**COMMUNITY SERVICES DEPARTMENT**

May 26, 2021

**Subject: Falcon Meadows at Bent Grass Filing No.1 (SF-2120)**

FILING NO. 1

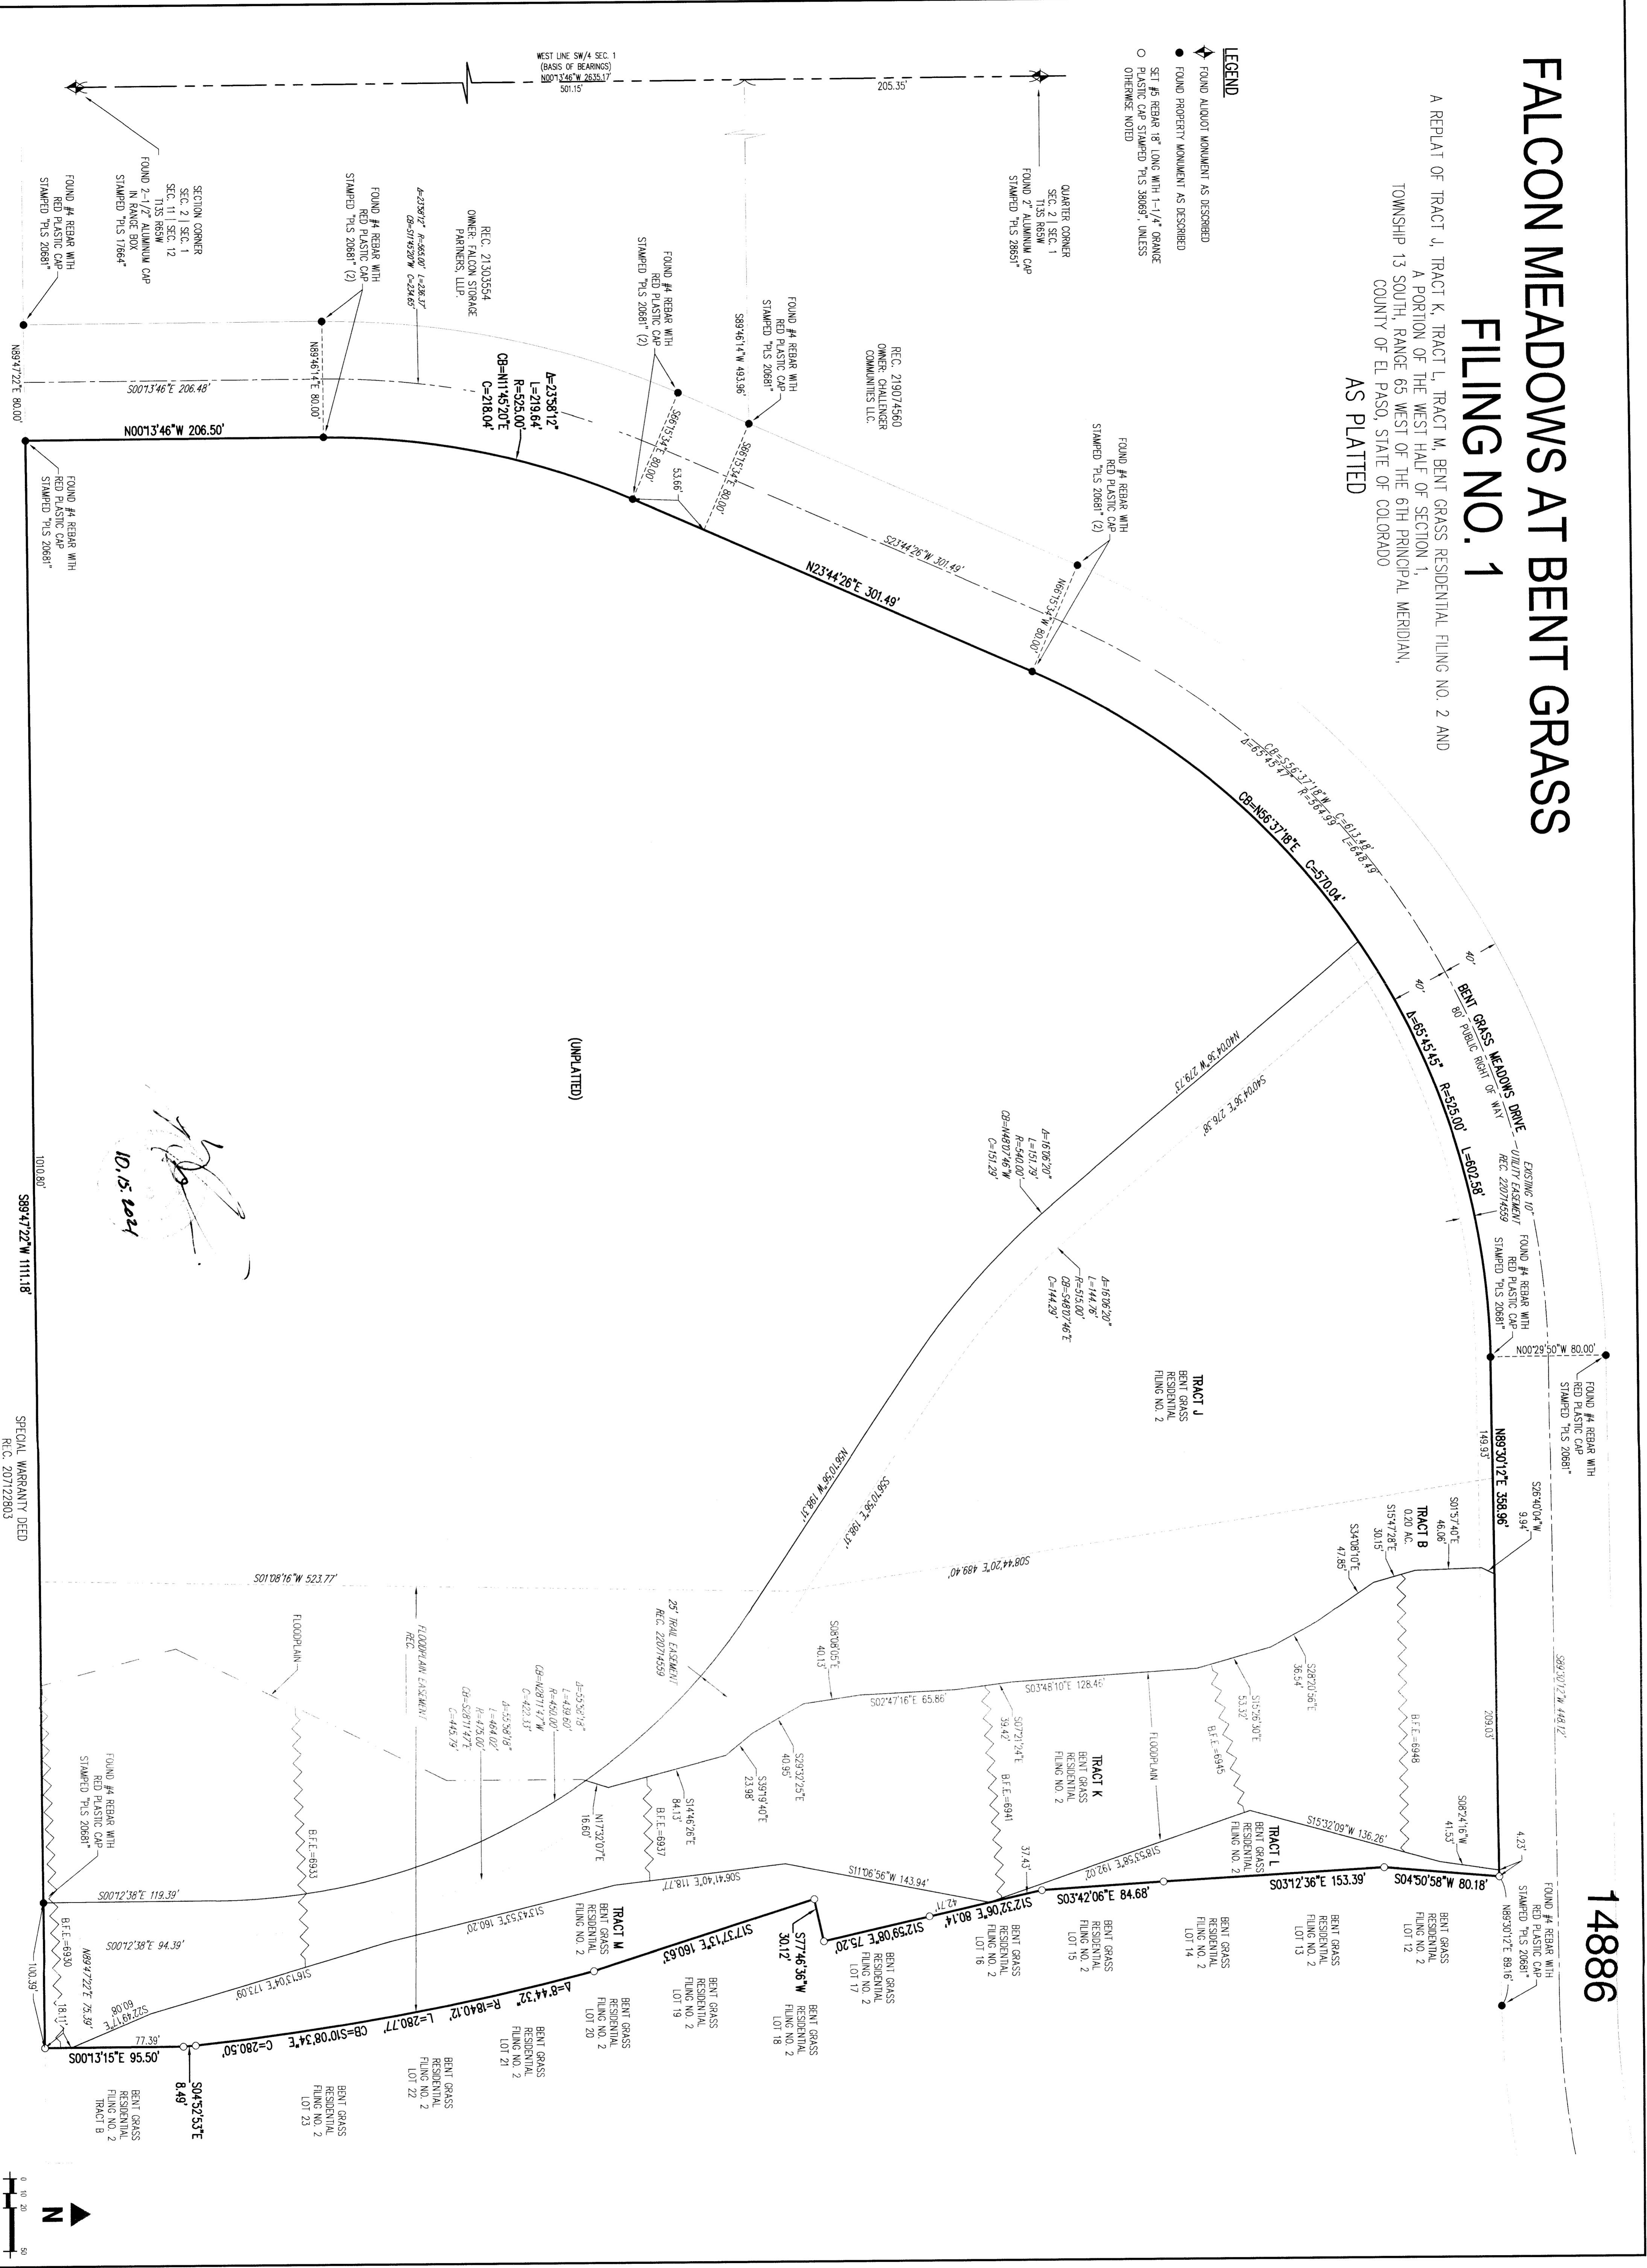
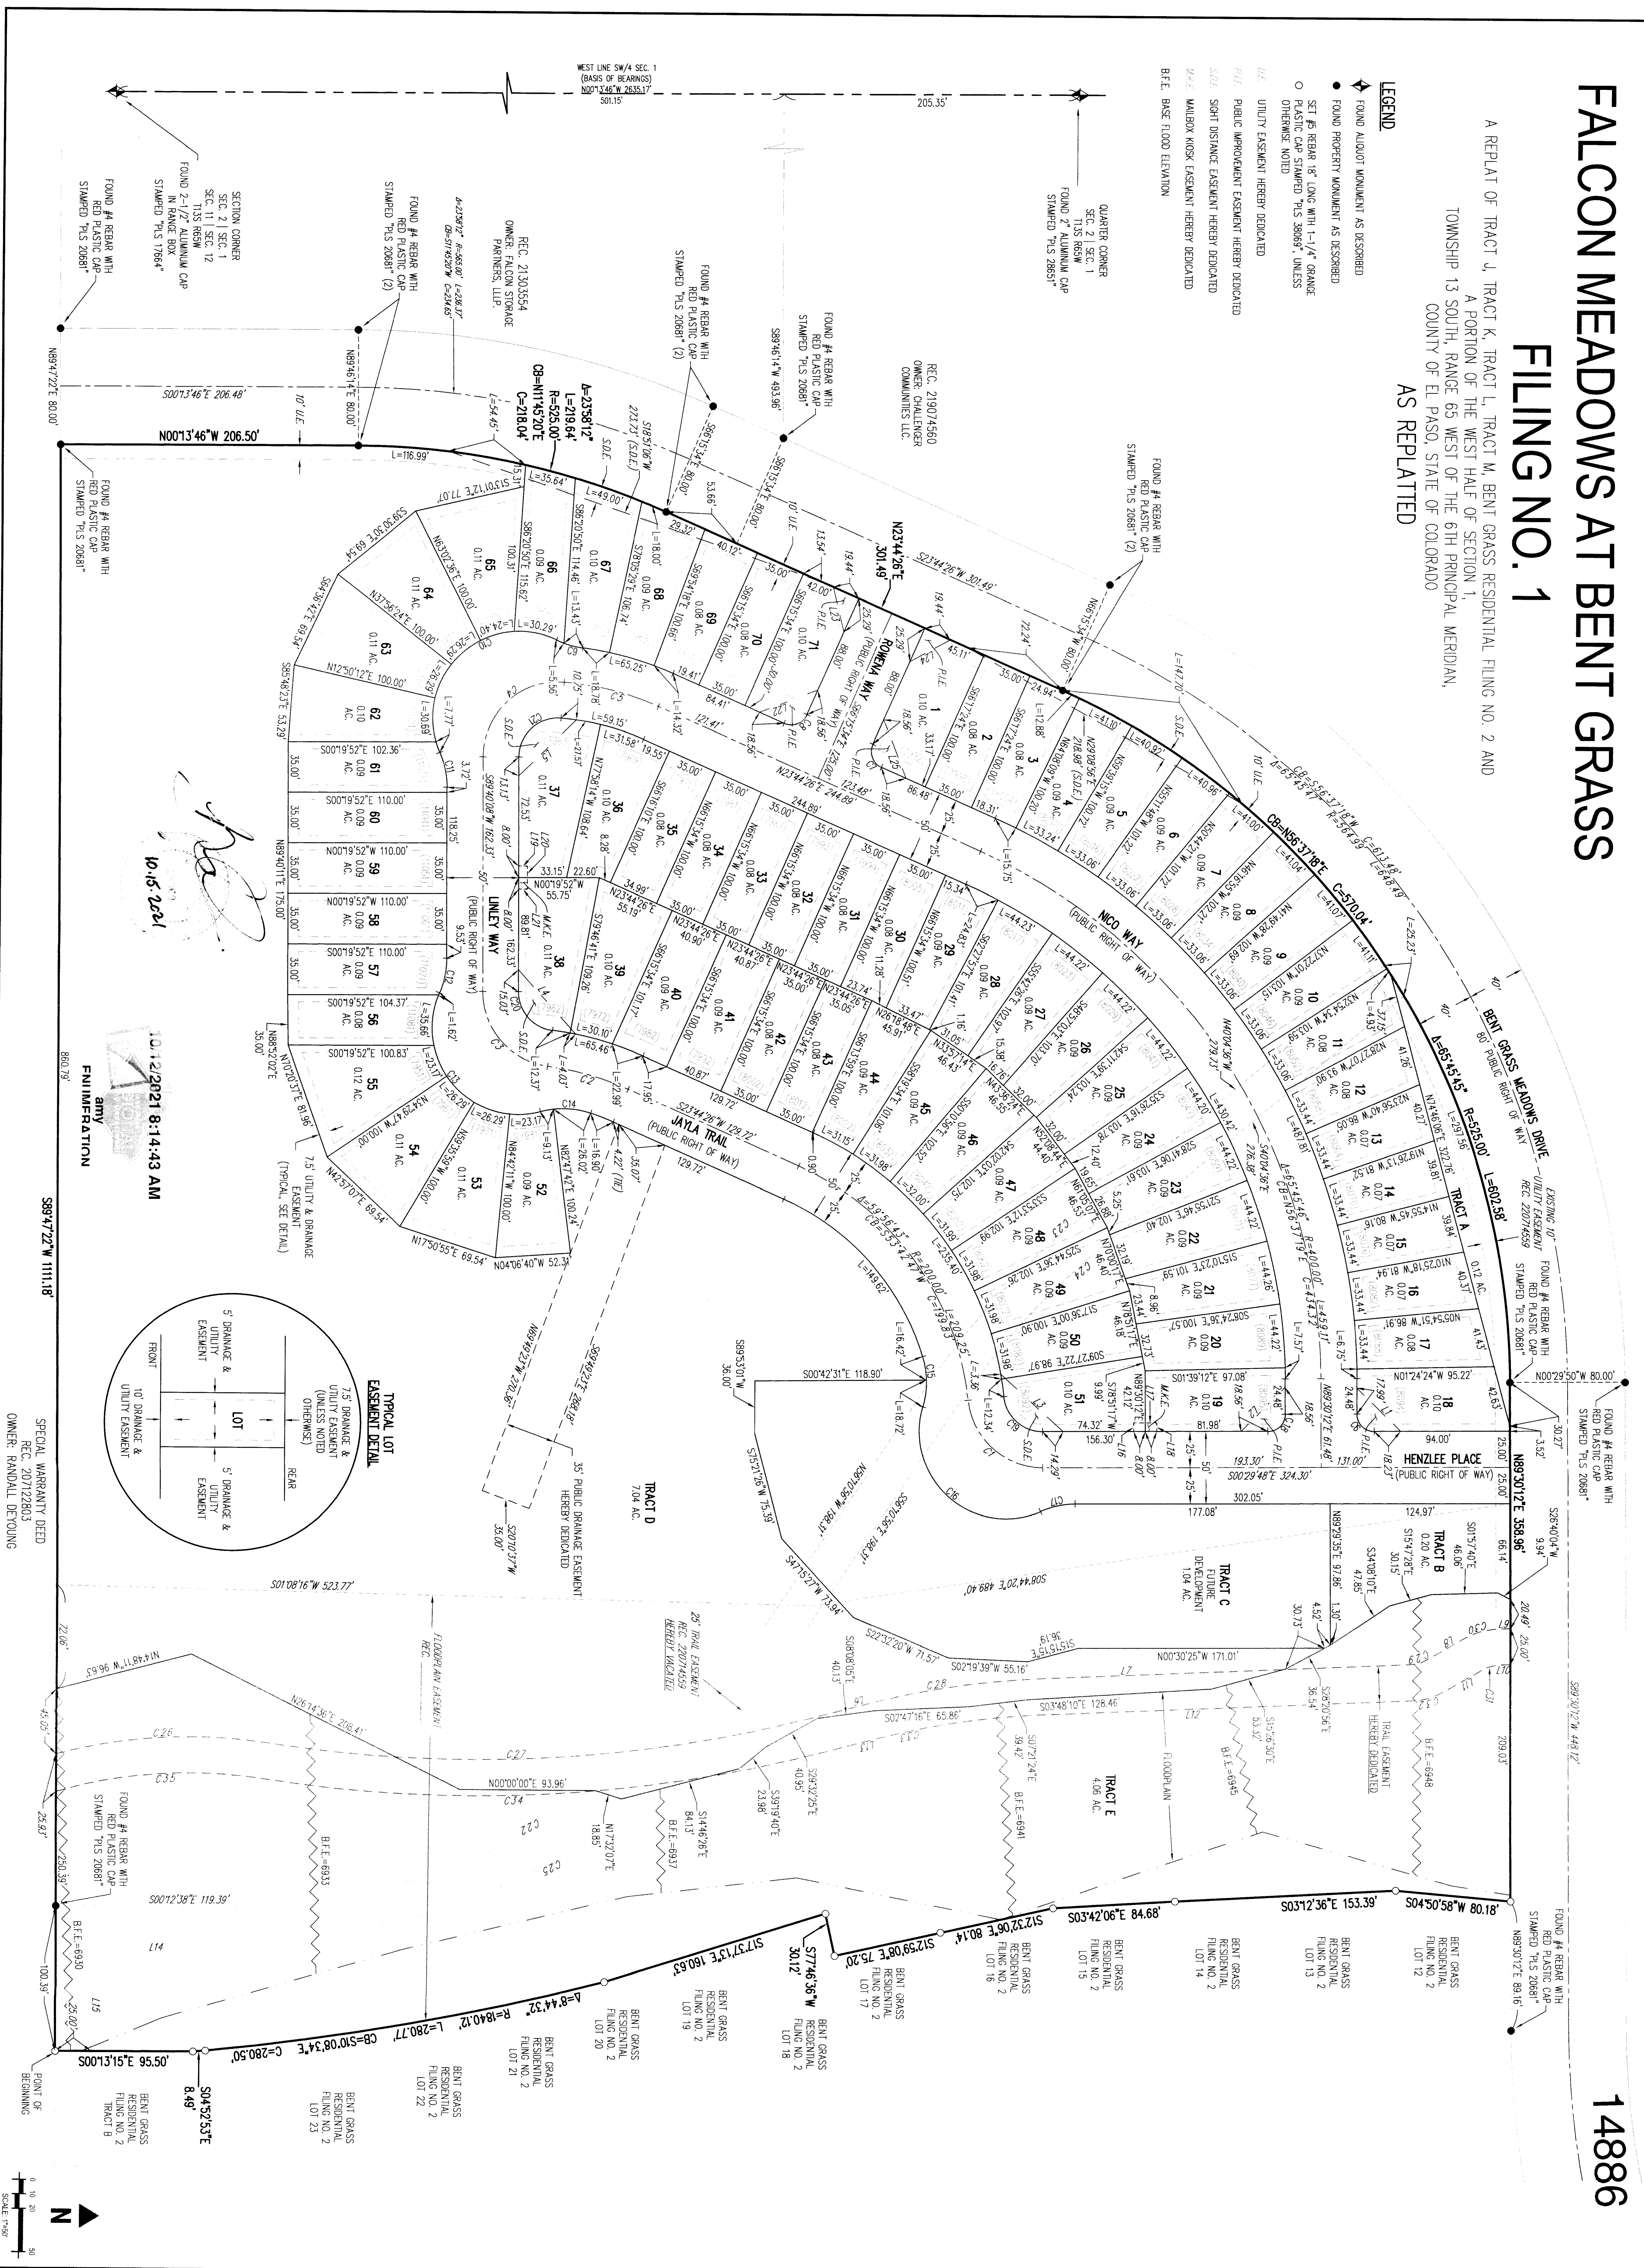
The 2013 El Paso County Parks Master Plan shows the proposed Woodmen Hills Secondary Regional Trail on the eastern edge of the project site. Staff notes that a "proposed trail" is shown on the grading plan but not on the plat. A 25-foot trail easement will need to be shown on the final plat through Tracts B,C,D,E that follows the west side of the proposed drainage channel and connects to the future trail north of Bent Grass Meadows Drive. No other parks, trails, or open space are impacted by this development, and the project site is not located within any Candidate Open Space Area.

*The Park Advisory Board recommends that the Planning Commission and the Board of County Commissioners include the following conditions when considering and / or approving the Falcon Meadows at Bent Grass Filing No.1 Final Plat: (1): Designate and provide to El Paso County a 25-foot trail easement along the proposed drainage channel through Tracts B,C,D,E that allows for public access, as well as construction and maintenance by El Paso County of the Woodmen Hills Secondary Regional Trail. Require fees in lieu of land dedication for regional park purposes in the amount of \$32,660 and urban park fees in the amount of \$20,590 will be required at time of the recording of the final plat(s). A park lands agreement may be an acceptable alternative to urban park fees provided the agreement is approved by the County and executed prior to recording the final plat.*
